Our ref: DOC19/1004584
Senders ref: SSD-10285

Subject: EES comments on Environmental Impact Statement for Royal Randwick Racecourse – Leger lawn Development– SSD-10285

Subject: EES comments on the Environmental Impact Statement for Royal Randwick Racecourse – Leger Lawn Development– SSD-10285

Figure 08: Landscape Plan
Source: Sturt Noble Associates

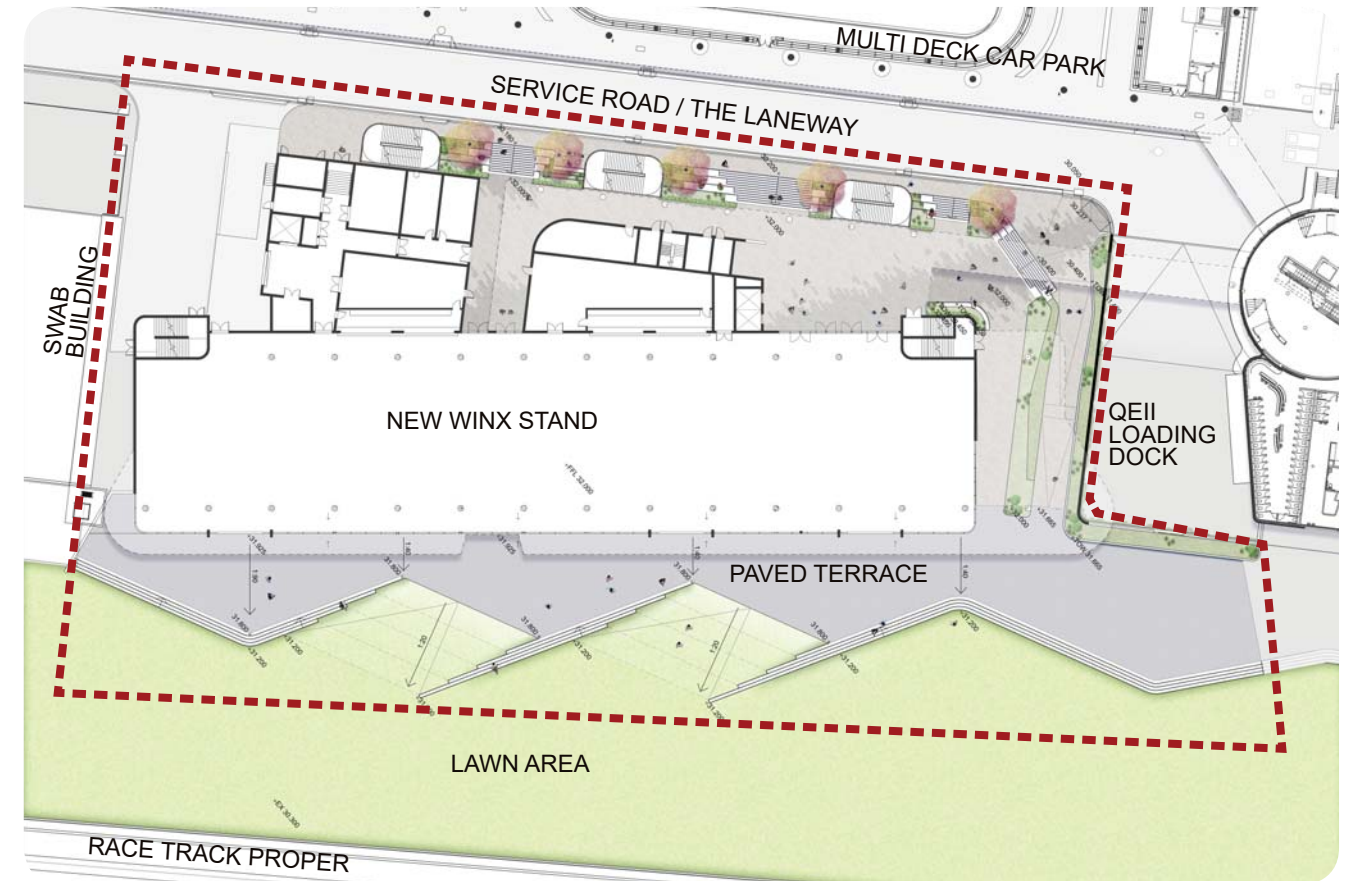
The EIS notes the landscape areas are to incorporate native species as per the Landscape Plan (page 104). The Indicative Planting Schedule also incorporates an invasive exotic species (Indian Hawthorn - *Rhaphiolepis indica*) and exotic species, such as:

- Red Hot Poker - *Kniphofia uvaria* 'Flamenco'
- Japanese Box – *Buxus japonica*
- 'Magnifica' Gardenia - *Gardenia augusta*.

The proponent needs to clarify if Red Hot Poker (*Kniphofia uvaria* 'Flamenco') behaves like *Kniphofia uvaria*. The seed of *Kniphofia uvaria* disperse by wind; it clumps vigorously and spreads rapidly and regrows from its rhizomes. Its dense clumping roots exclude the roots of other plants and prevents the germination of their seeds. It also favours sensitive and fragile bushland such as swamps, moist forest and creek lines (www.weedsbluemountains.org.au).

The Indicative Planting Schedule also proposes to use native species which are not locally occurring such as the Firewheel tree (*Stenocarpus sinuatus*) which is an Australian rainforest tree. Its natural distribution is from the Nambucca River in New South Wales to the Atherton Tableland in tropical Queensland.

- the landscaping at the site uses a diversity of native trees, shrubs and groundcover species from the relevant local native vegetation communities (local provenance material) that once occurred in this locality to improve biodiversity (rather than use exotic species and non-locally occurring native species)
- the landscape plans are amended, and a condition of consent is included which requires this SSD to use local native provenance species from the relevant local native vegetation communities which once occurred in this locality.

1. Invasive exotic species are removed from the Landscape Plan and replaced by a diversity of local native provenance trees, shrubs and groundcover species (rather than exotic species or non-local native species) from the relevant native vegetation community which once occurred in this locality.

5. The Landscape Plan shall include details on:
 - a) the native vegetation community that occur or once occurred in this locality
 - b) a list of local provenance tree, shrub and groundcovers to be used in the landscaping

- c) the quantity and location of plantings
 - d) the pot size of the local native trees to be planted
 - e) the area/space required to allow the planted trees to grow to maturity

- f) Plant maintenance regime. The planted vegetation should be regularly maintained and watered for 12 months following planting. Should any plant loss occur during the maintenance period the plants should be replaced by the same plant species
